Ribble Valley Borough Council  
Housing & Development Control

**Planning application no.: 3/2022/0247**

**Proposal: Proposed single storey rear extension, detached garage and car port. Conversion of the integral garage and associated alterations.**

**Location: Lynwood Pendleton Road Wiswell BB7 9BZ**

**PROPOSED GARAGE
GROUND FLOOR PLAN**
Scale 1:50

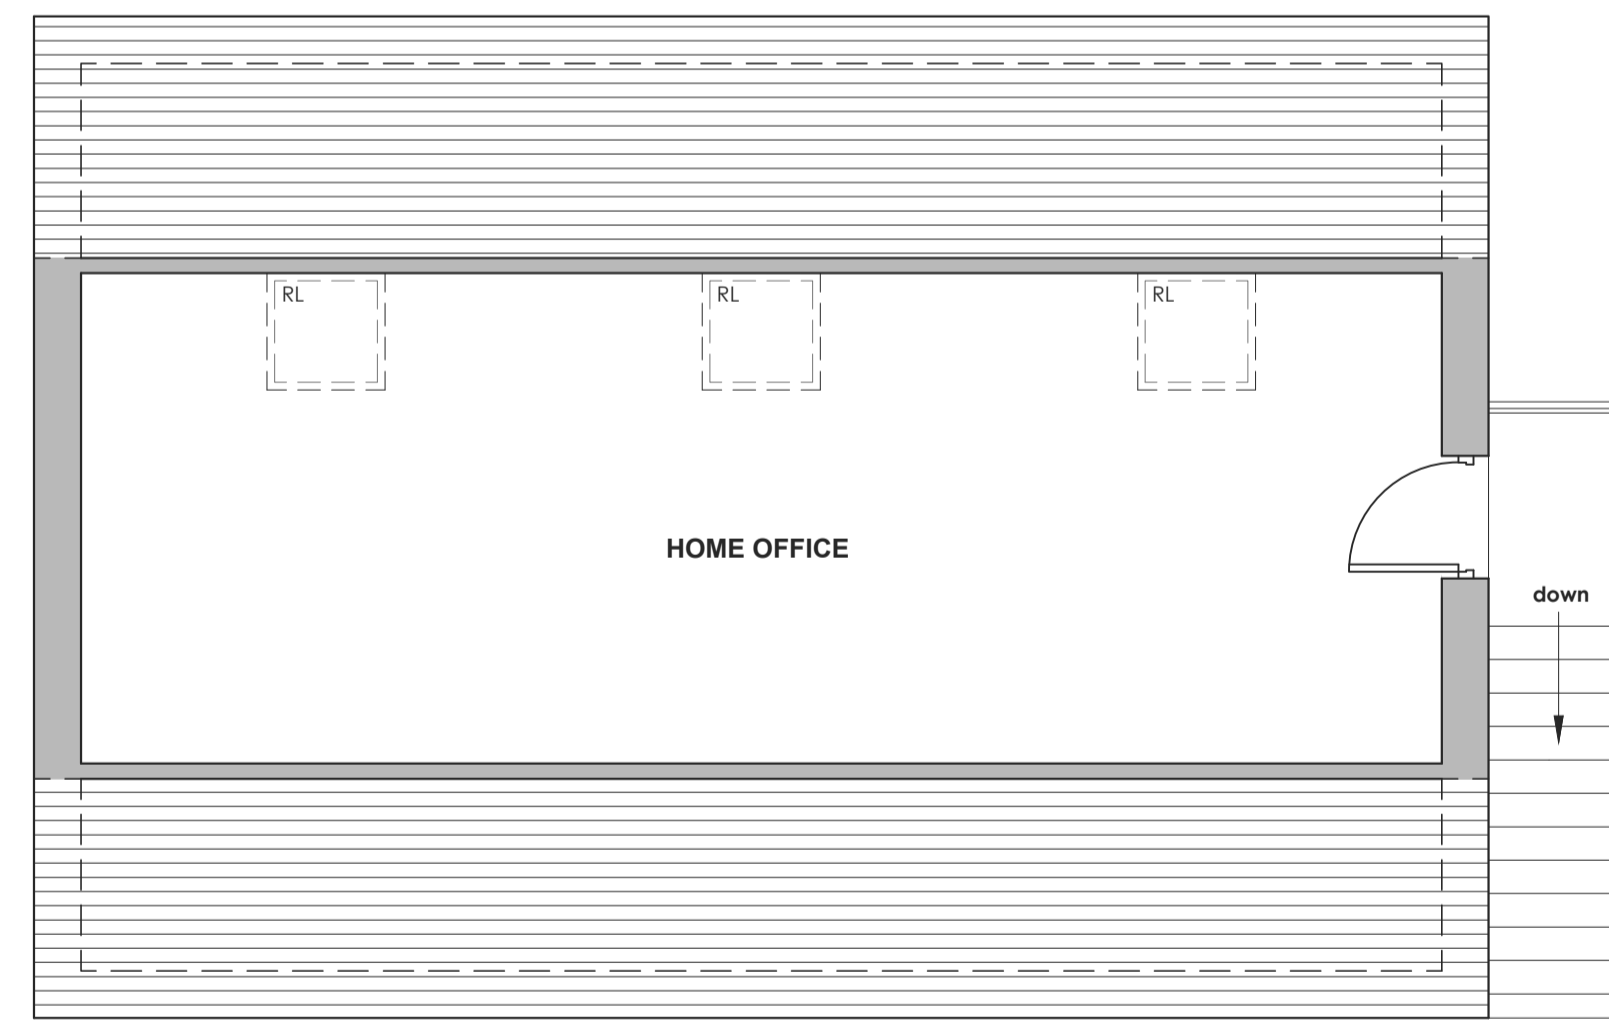
- All garage facilities shall have facility of an electrical supply suitable for charging an electric motor vehicle. Reason: - in order to promote sustainable transport as a travel option and reduce thereby carbon emissions.
- The parking areas must be constructed of a bound porous material and created before first occupation up until the lifetime of the dwellings existing in their proposed state. Reason: To ensure that satisfactory parking is provided before the dwelling hereby permitted becomes operative.
